Application No: AB/114/20/PD
Site Address: Riverside House 2 Fitzalan Road Arundel BN18 9JS
Description of works: Notification for Prior Approval under Schedule 2 Part 1 Class AA for a additional 2 storeys on existing dwelling house.

Objection to Planning Application
AB/114/20/PD
Riverside House
2 Fitzalan Road
Arundel
BN18 9JS

Drawing Title:
PROPOSED PLANS

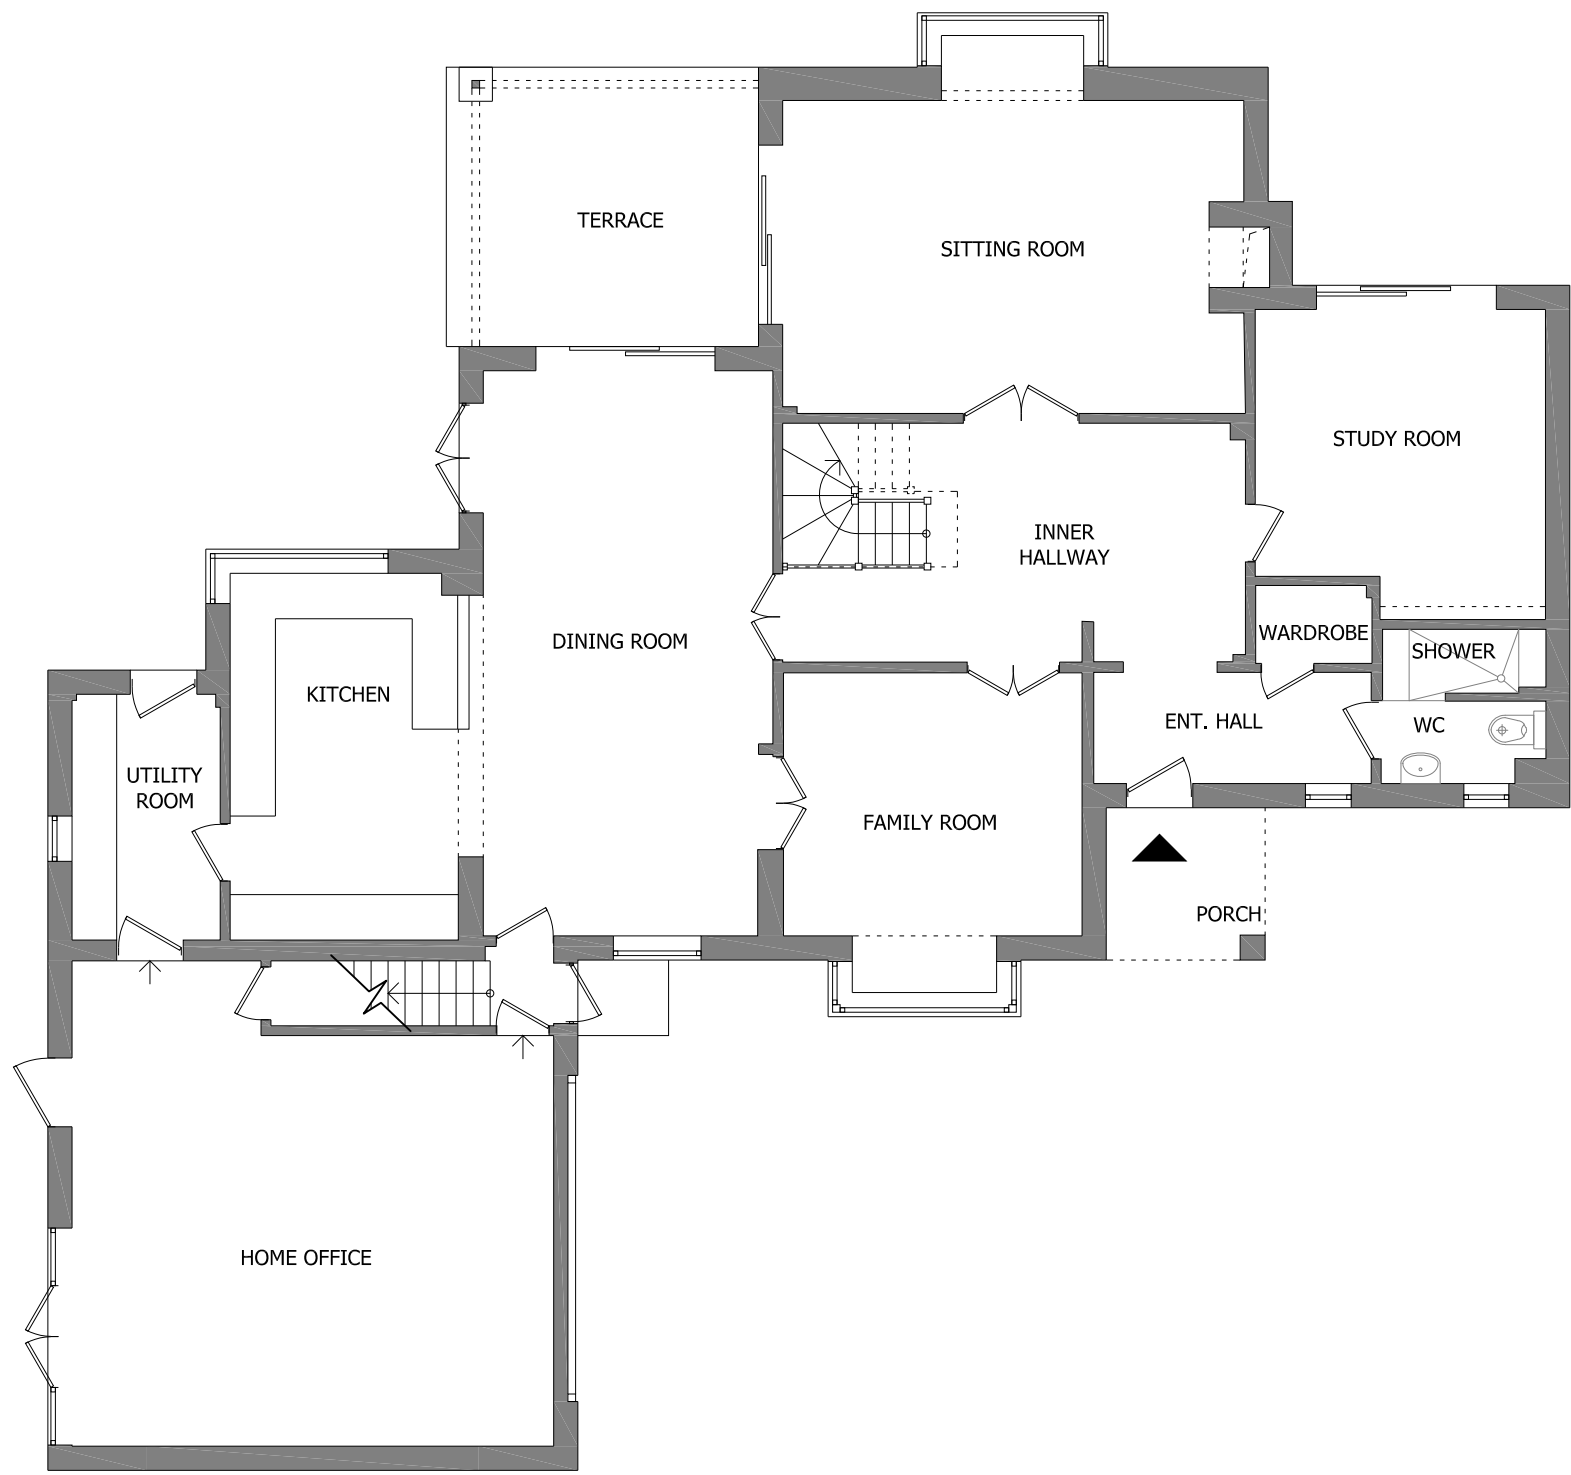
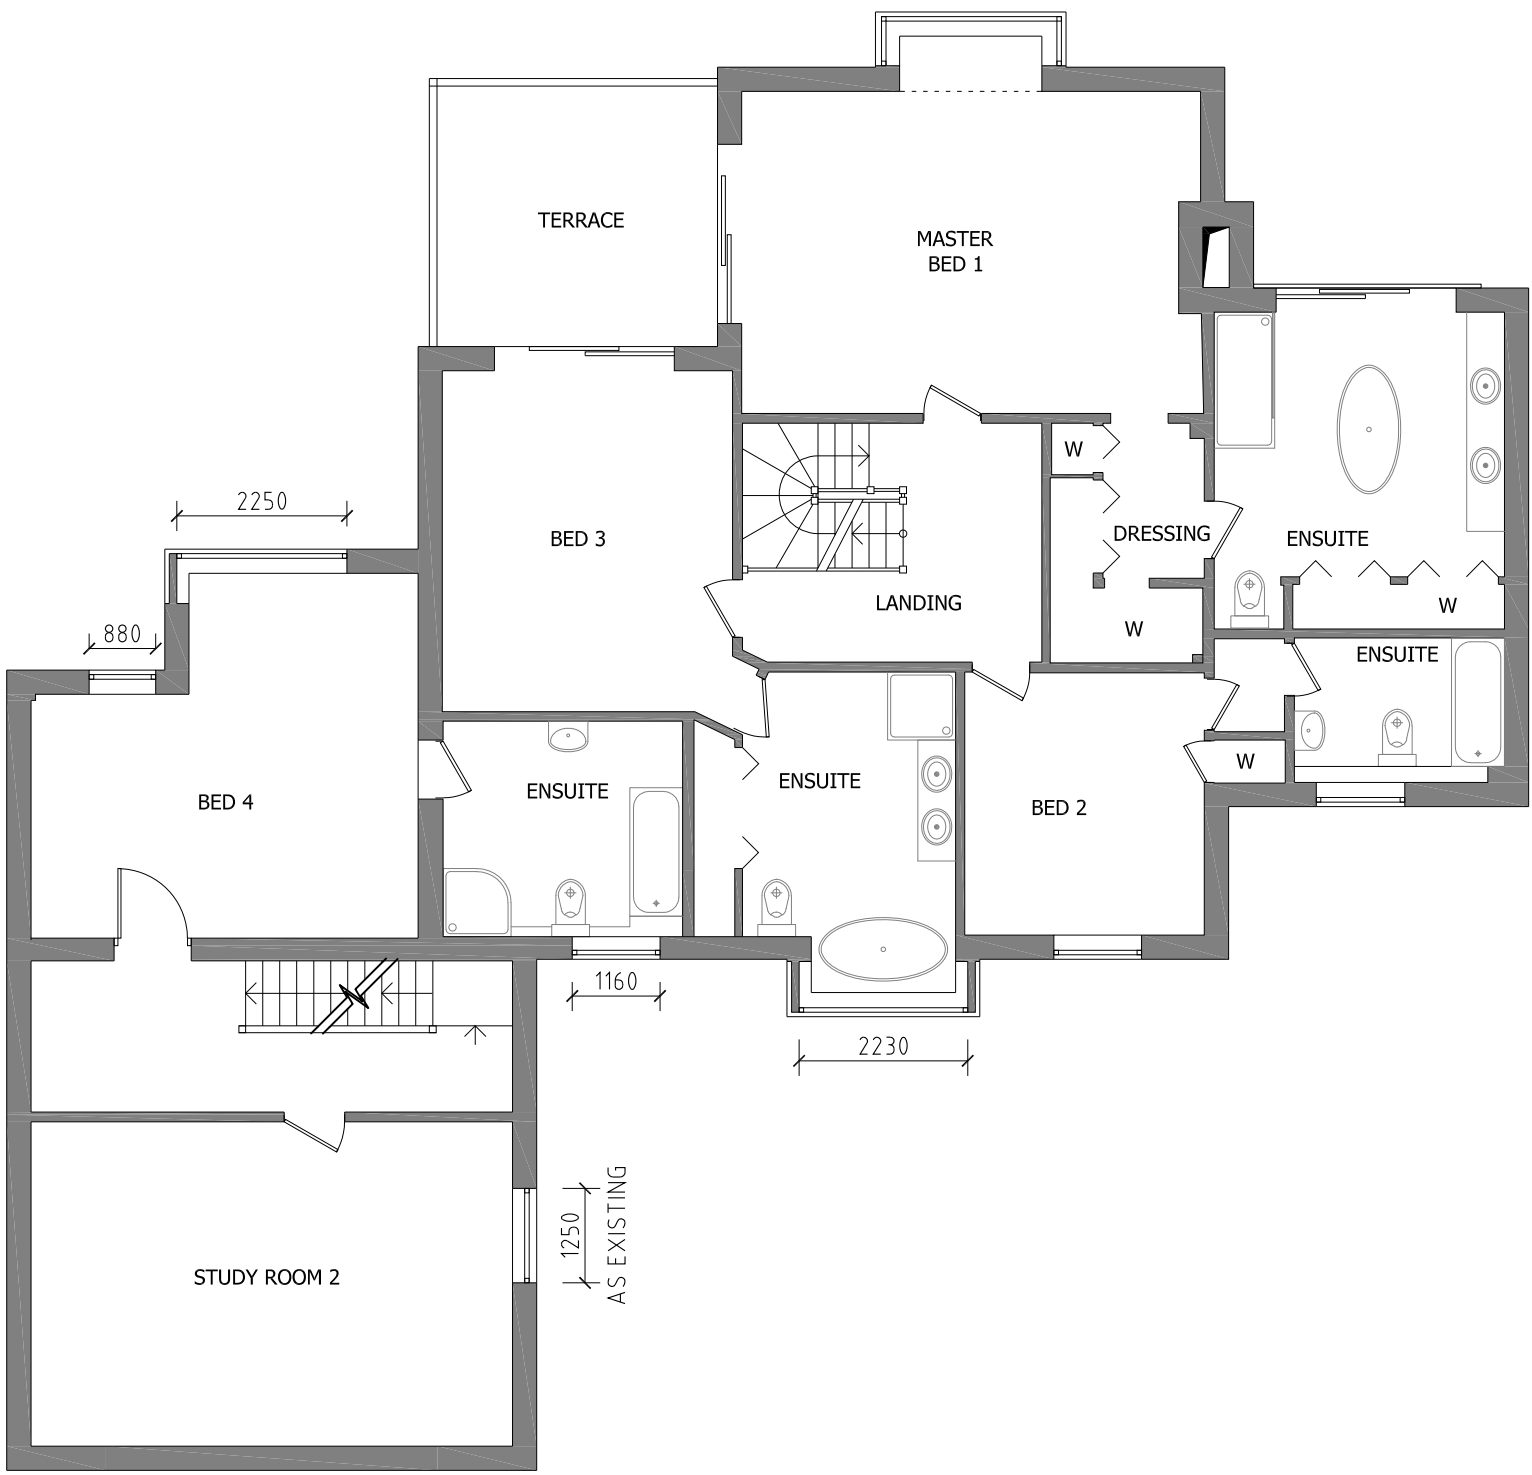
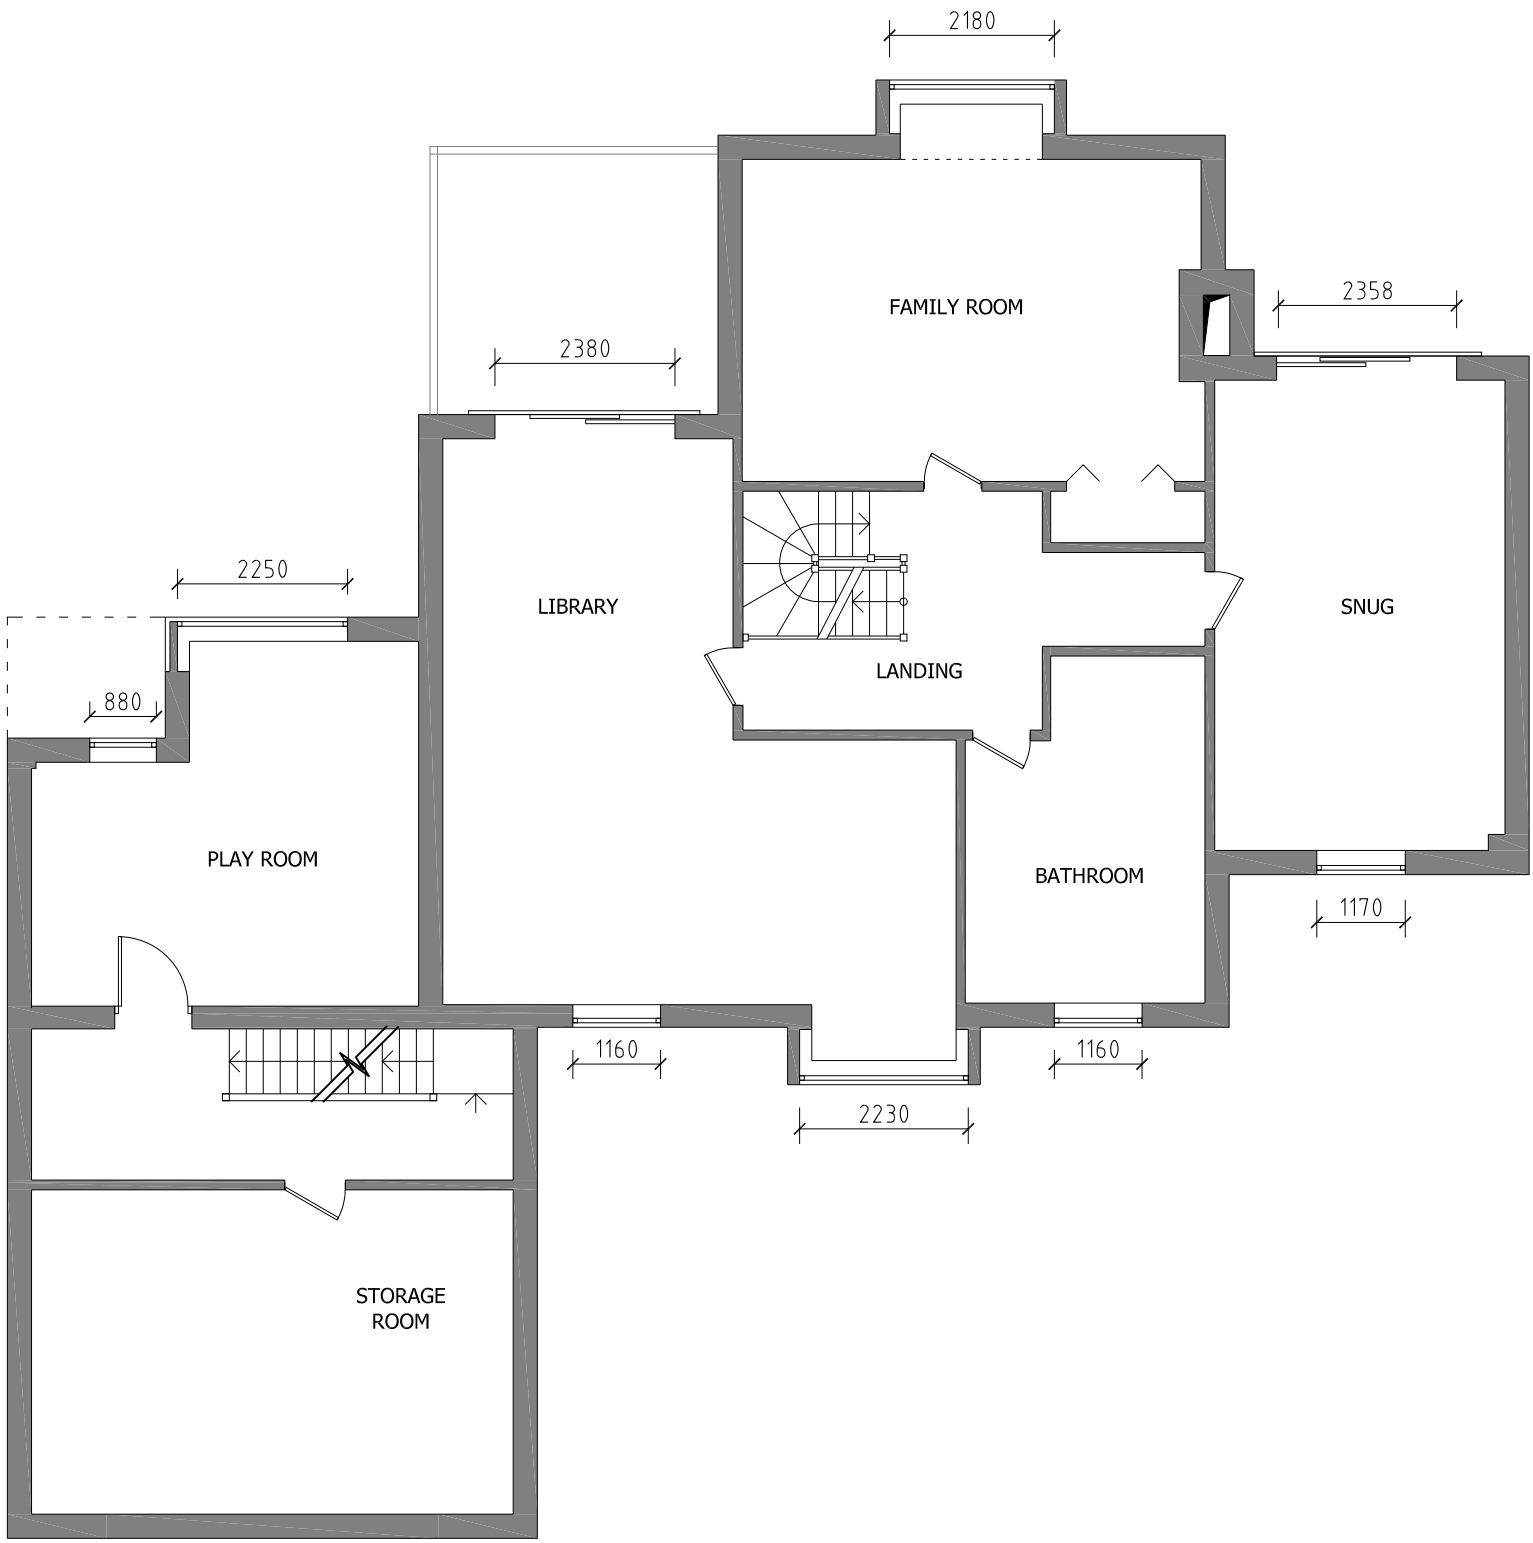
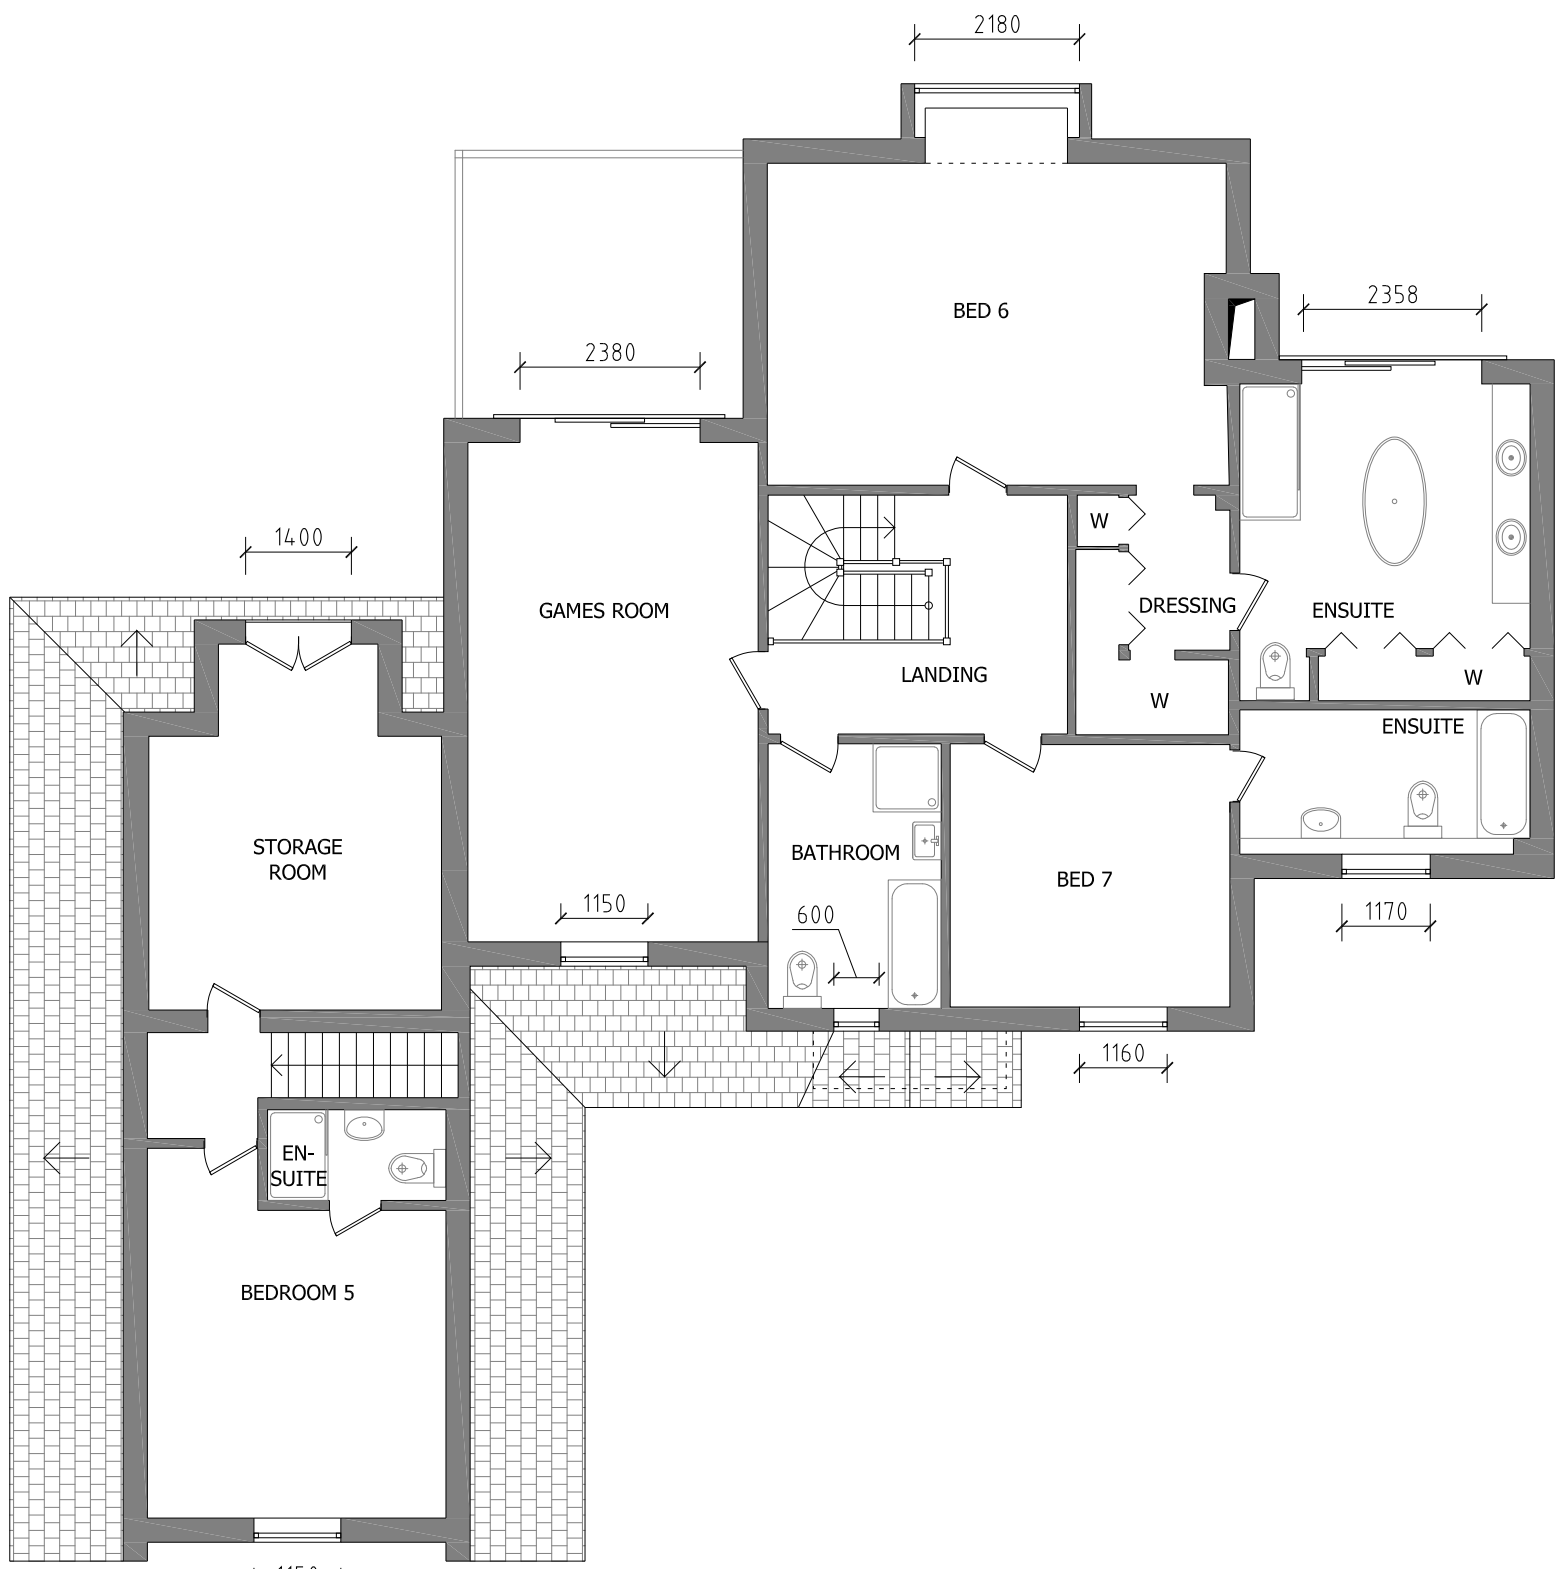
4. I note from the plans that there are some eleven proposed bathrooms, the future intent for which is surely a multi-occupancy dwelling of several flats. If this is indeed the case it should be declared as such, and not become an example of incremental development by stealth. If the intent is for a multi-occupancy building then parking requirements should be appropriately scaled, and the increase in traffic taken into consideration at this stage of the planning application.
